Consultation Response from KC, Lead Local Flood Authority		
2021/90019 Land South of Helme Lane, Meltham, Huddersfield, HD9 5QN		
Variation of condition 2. (plans and specifications) on previous permission no. 2018/92937 for erection of 50 dwellings and associated works		
Date Responded: 4th February 2021	Responding Officer: Paul Farndale	Responding Ref:

SECTIONS THROUGH
WATERCOURSE ON NORTHERN SITE
BOUNDARY

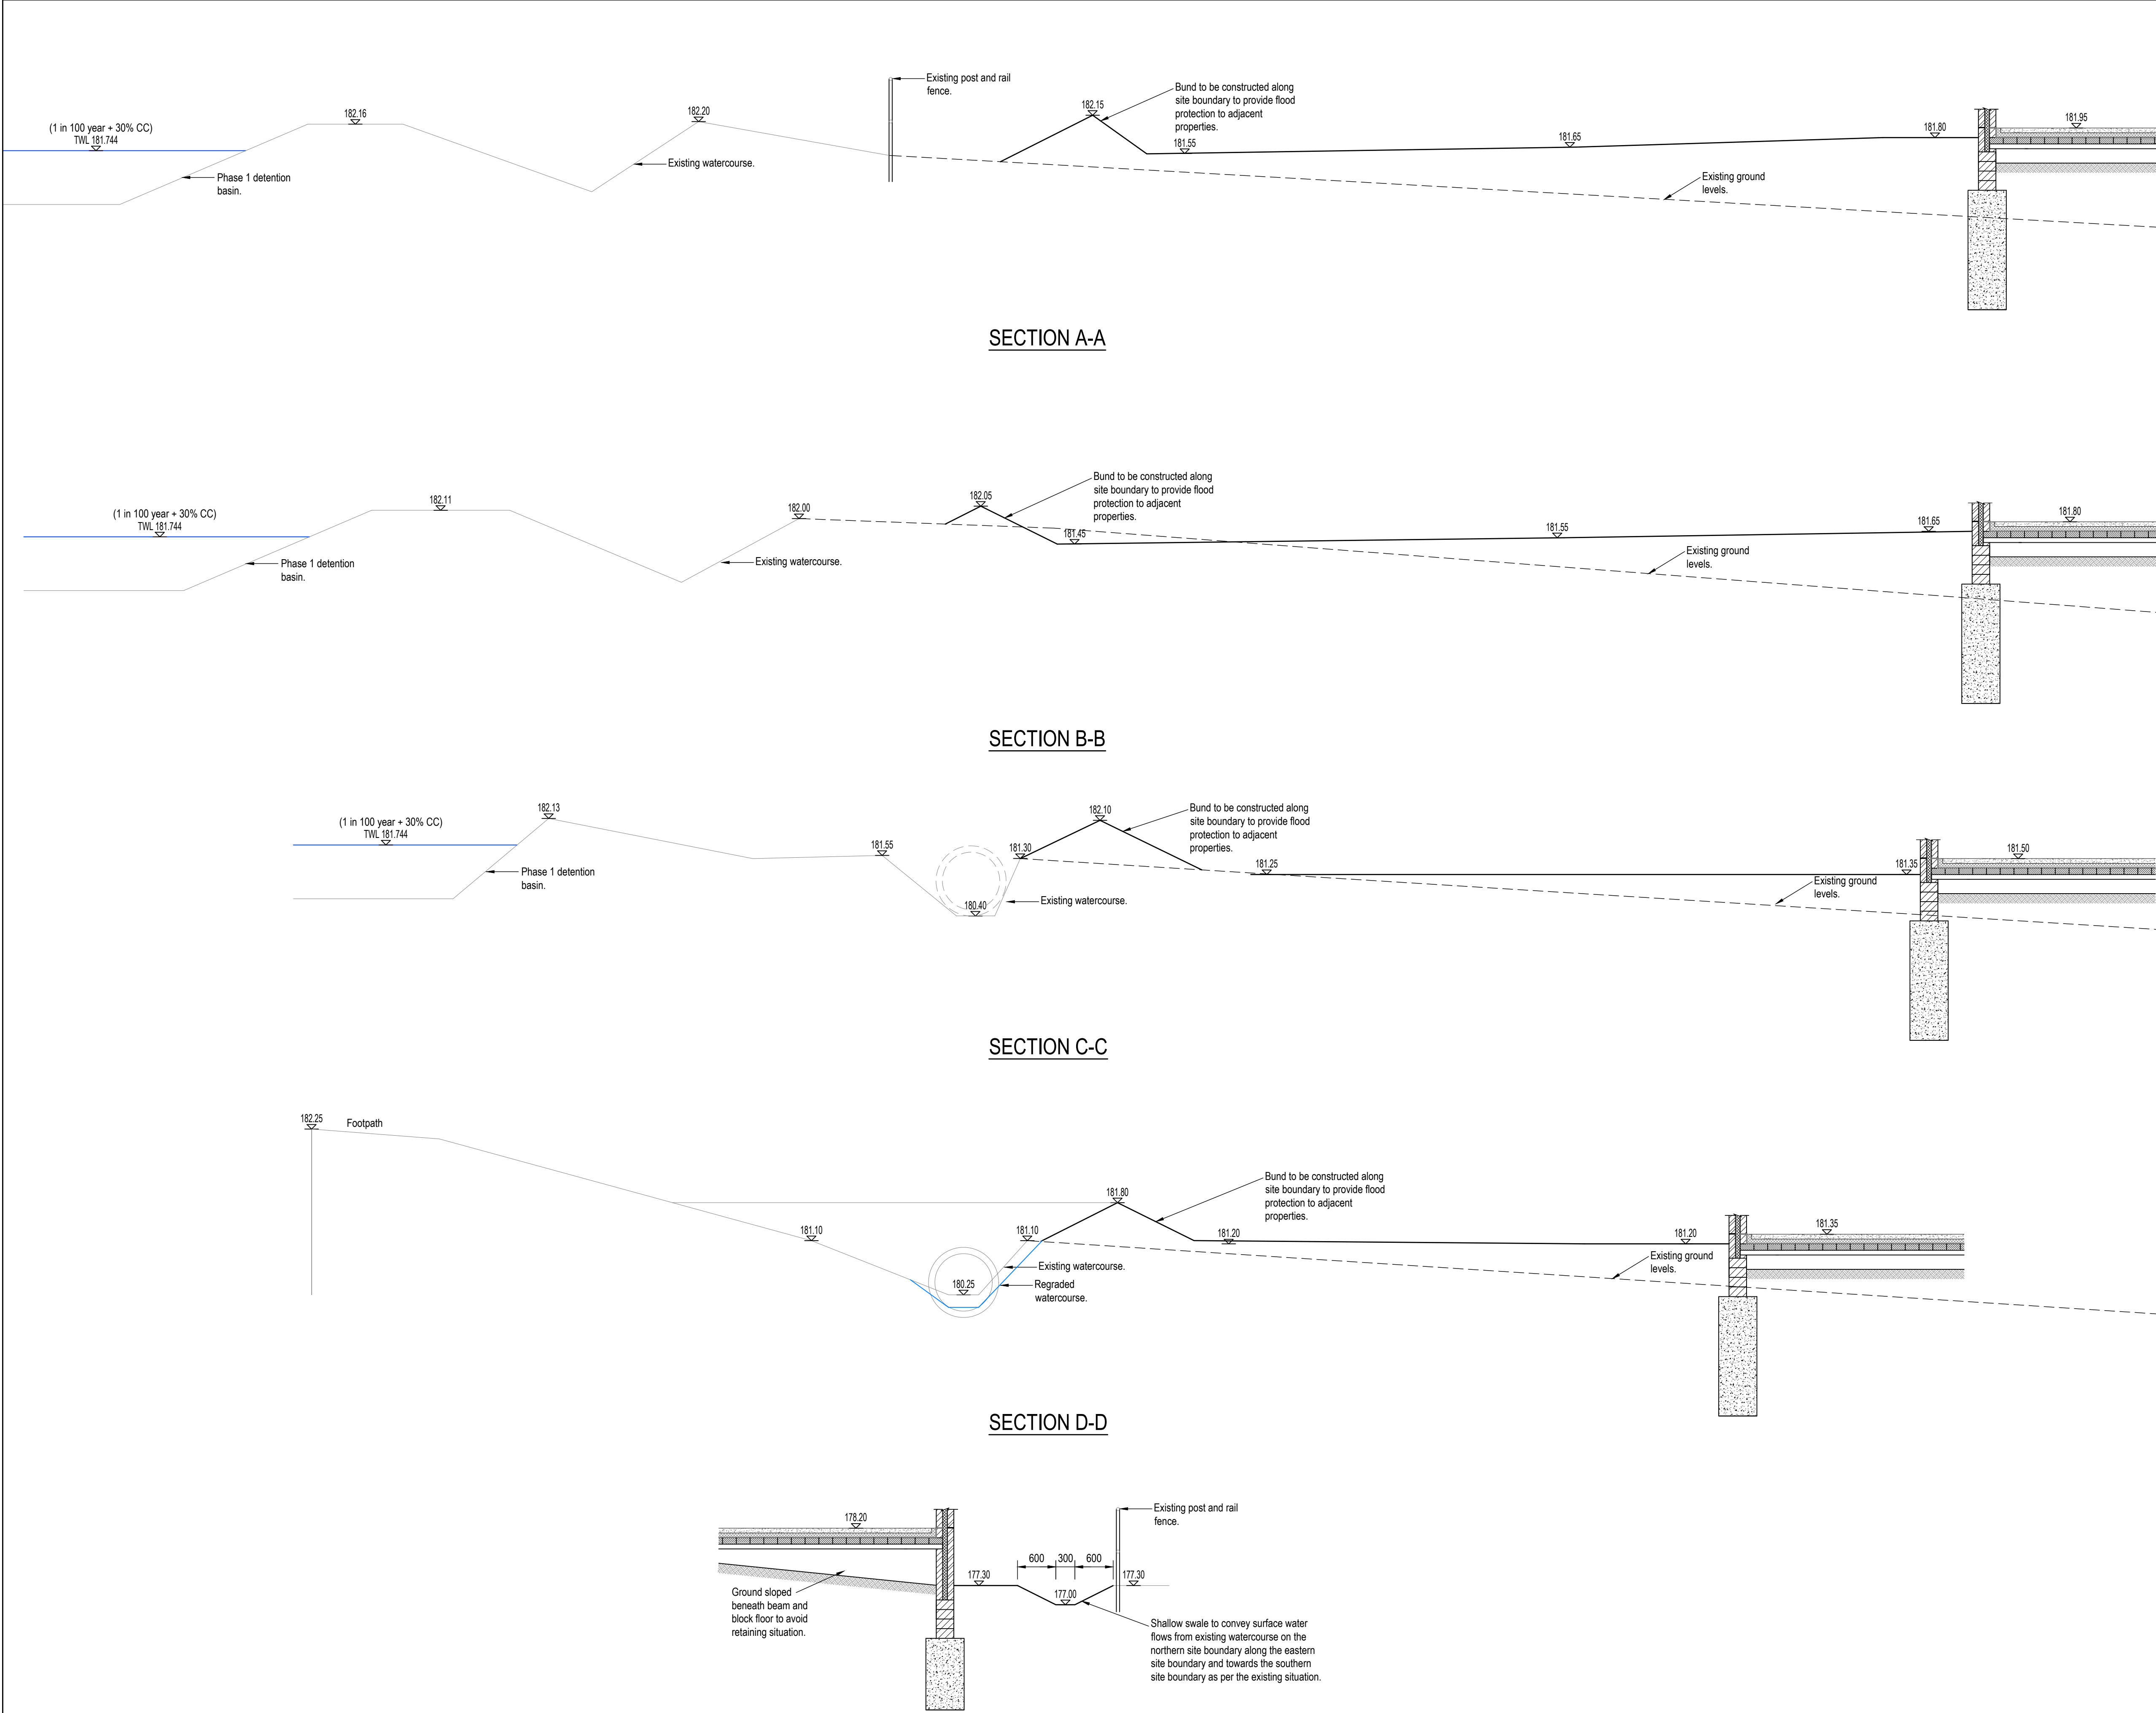
Kirklees LLFA OBJECTS to this application until we are re-assured that the flood risk bund to protect the northernmost properties is clearly included in the design.

It is noted on drawings that the protection bund immediately to the south of the watercourse that separates phase 1 and phase 2 is either missing or not made clear on all drawings. This bund is designed to protect the northernmost properties of phase 2 from any backing up and overspilling of the watercourse in a southerly direction.

The LLFA is concerned as we note that this has not yet been constructed on site and is a vital part of flood management.

A revision, in light of the inclusion of the substation, is necessary.
